ASSESSMENT REPORT

Section 75W Modification

Lakes Estate Residential Subdivision, North Boambee Valley (MP 05_0129 MOD 1),
Coffs Harbour Local Government Area

Figure 7: Comparison of Approved and Proposed Subdivision Layout (Approved Layout Left, Proposed Layout Right)

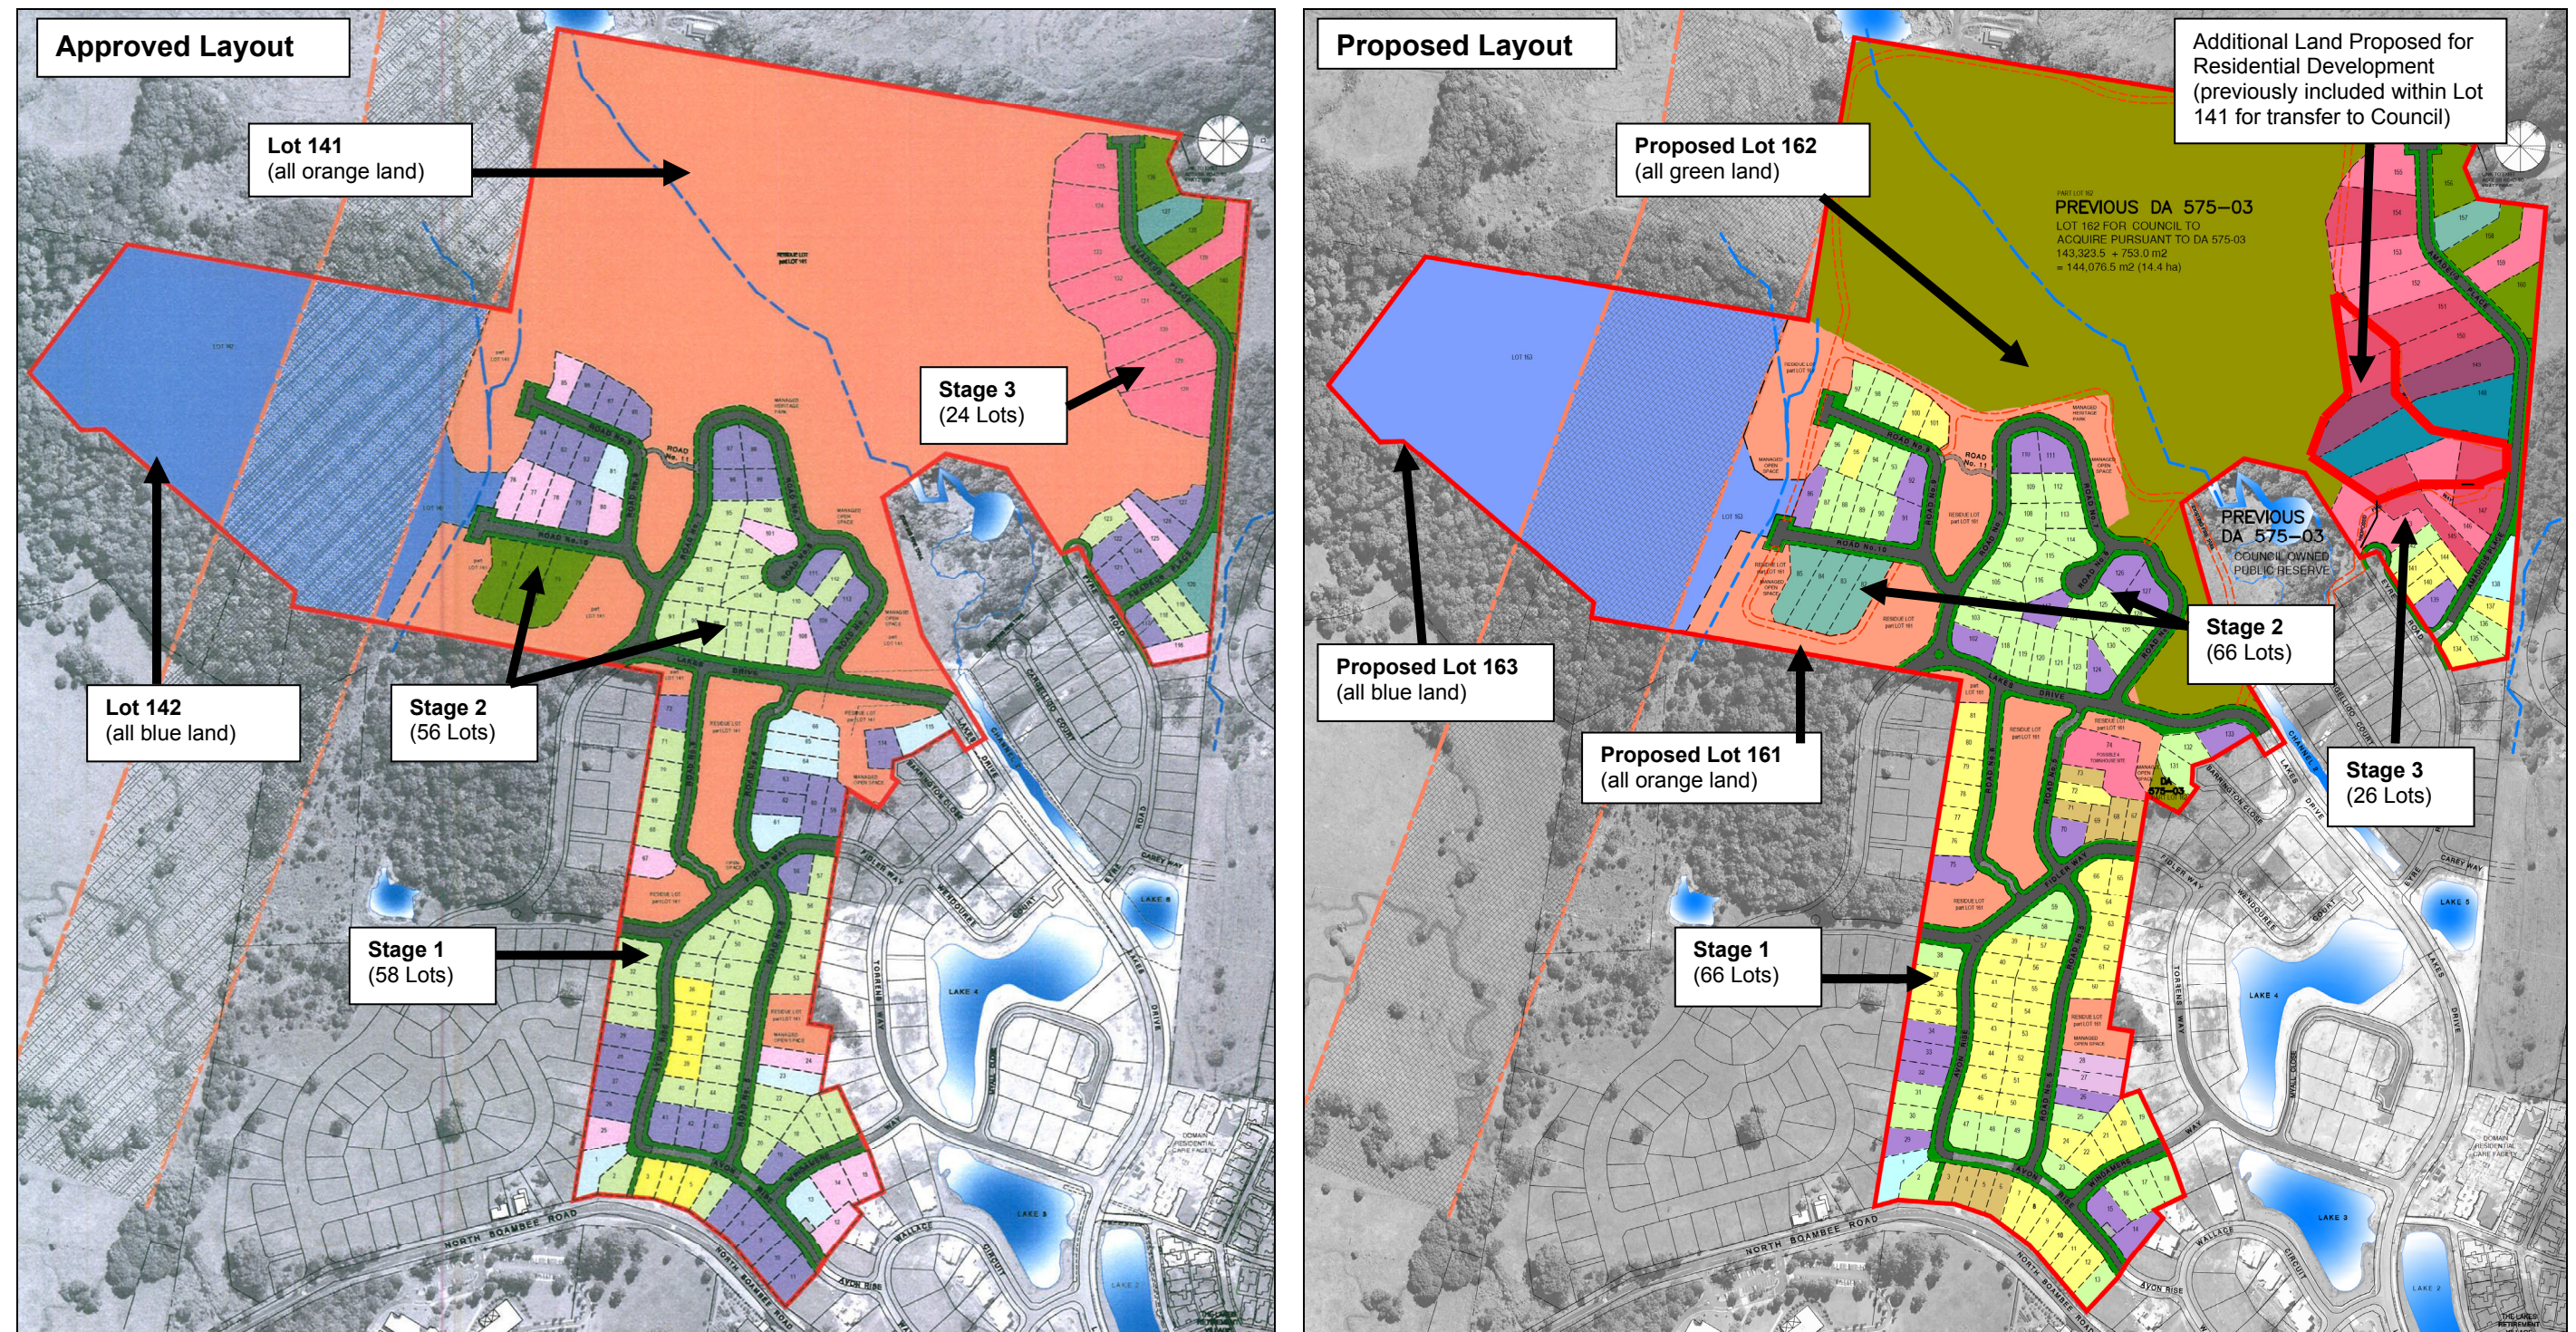
In terms of the proposed subdivision layout for Stage 3, the Department notes that the Council and the RFS raised concerns with the following aspects of the proposal:

- the potential need to clear primary and secondary Koala habitat and the potential reduction in the endangered ecological communities (EEC) protection buffer (see **Figure 8**);
- the proposed reduction in the size of Lot 141 (see **Figure 7** above); and
- the configuration of the proposed fire trails.

The Department has assessed the proposed modifications to the layout of Stage 3 and notes that:

- the land within proposed lots 143 and 145 to 154 immediately west of the approved fire trail contains significant vegetation, and fragmenting this land is likely to result in a poor environmental management outcome; and

- whilst the modification request does not seek to alter the location of the fire trails approved within Stage 3, the proposed subdivision layout would result in the fire trails bisecting lots 143 and 145 to 154, which is inconsistent with the provisions of section 4.1.3(3) of PBP 2006.

In order to provide an appropriate environmental outcome, and ensure compliance with the requirements of PBP 2006, the Department has recommended a condition requiring all of the land to the west of the fire trail within Stage 3 to be incorporated into Part Lot 162. This will ensure the conservation and bush fire management outcomes are maintained as per the intent of the current Project Approval.

Figure 8: Location of Primary and Secondary Koala Habitat and EEC Buffers

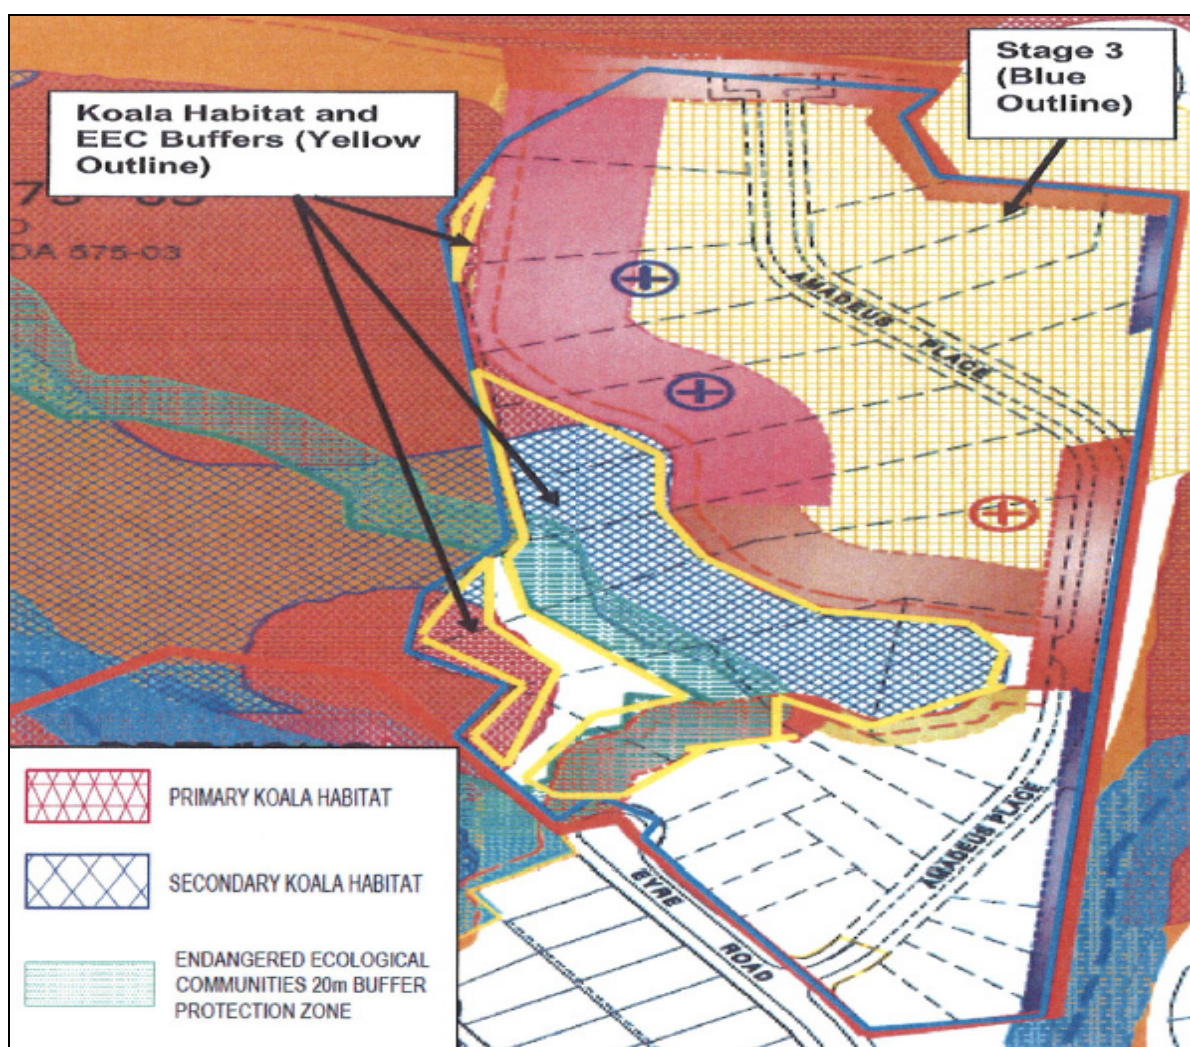
- the revised lot layout within Stage 3 is not supported on the basis that the revised design would require the clearing of additional Koala habitat and land within the Lowland Rainforest EEC buffer, and does not provide appropriate emergency access for emergency vehicles (i.e. the RFS).

Figure 9: Pedestrian and Road Links Required under Condition B1(b) and (c)

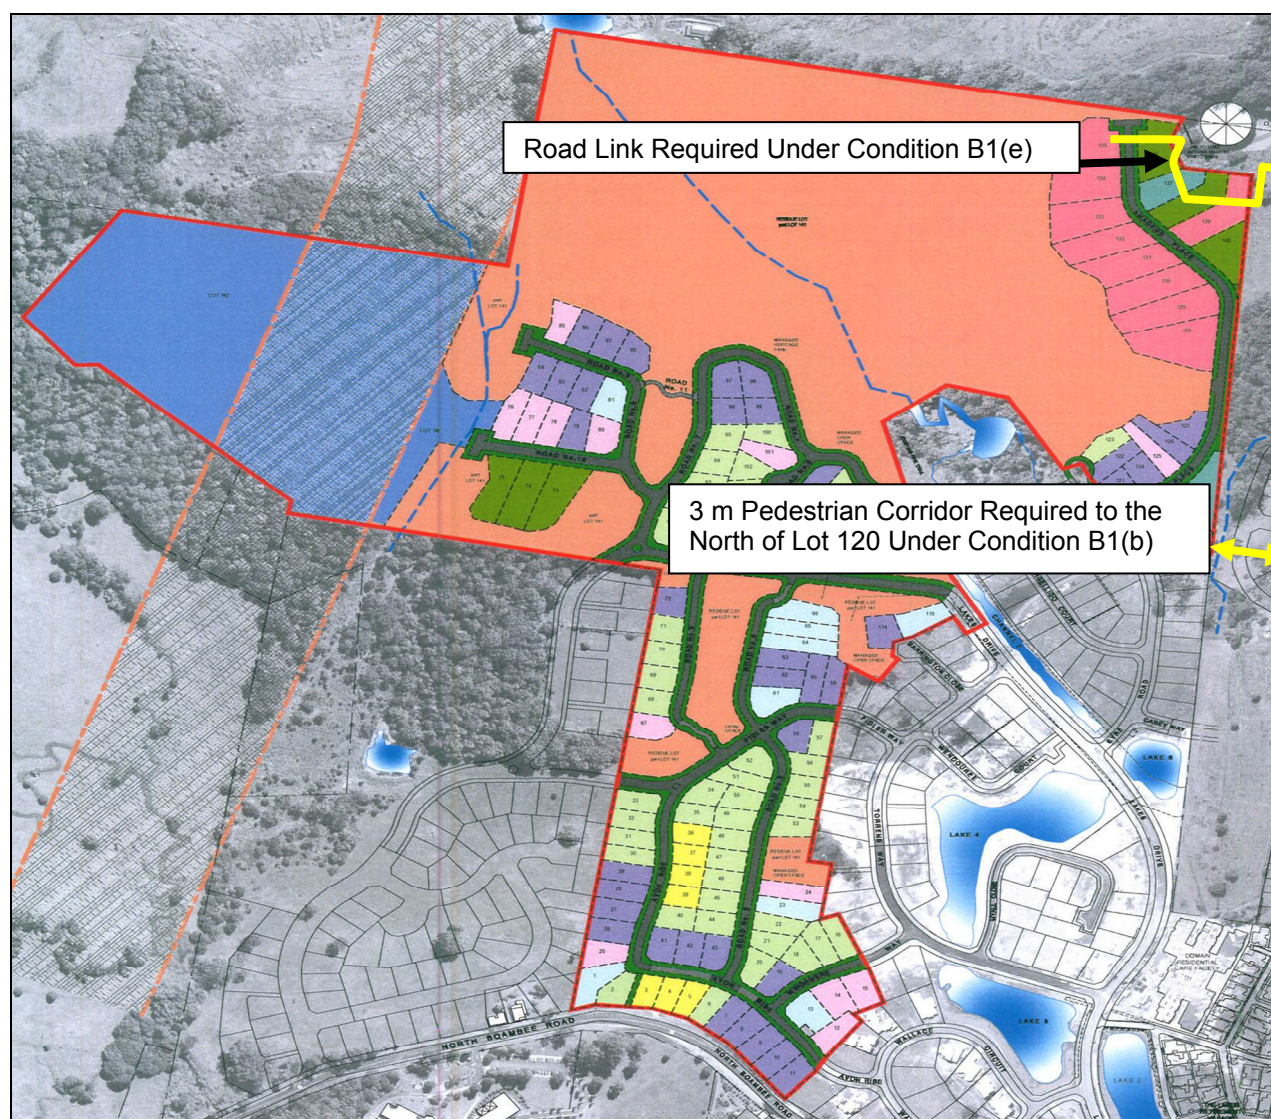
The Department notes that the Council and a number of local residents raised the following concerns with the deletion of the 3 m wide pedestrian corridor between the site and Halls Road:

- the removal of this connection would reduce the level of accessibility to the public open space within the Lakes Estate for residents east of Halls Road; and
- the removal of the pedestrian corridor would decrease permeability within the locality and would significantly increase the travel distance for children accessing Bishop Druitt College.

In addition, both the Council and the RFS raised concern with the removal of the road link between Amadeus Place and the Kratz Drive estate on the basis that the removal of this link would reduce accessibility for emergency vehicles, and the Proponent has not identified a viable alternate access route.

- the road link between Amadeus Place and Kratz Drive was required to ensure emergency service vehicles could access the residential lots within Stage 3B in the event of a bush fire, and no viable access has been proposed by the Proponent. Accordingly, its removal is not supported; and
- the removal of the pedestrian corridor connecting the site to Halls Road is inappropriate as it will significantly reduce pedestrian connectivity within the locality, particularly for school students attending Bishop Druitt College (see **Figure 10**). Given the above, the Department does not support the removal of this connection.
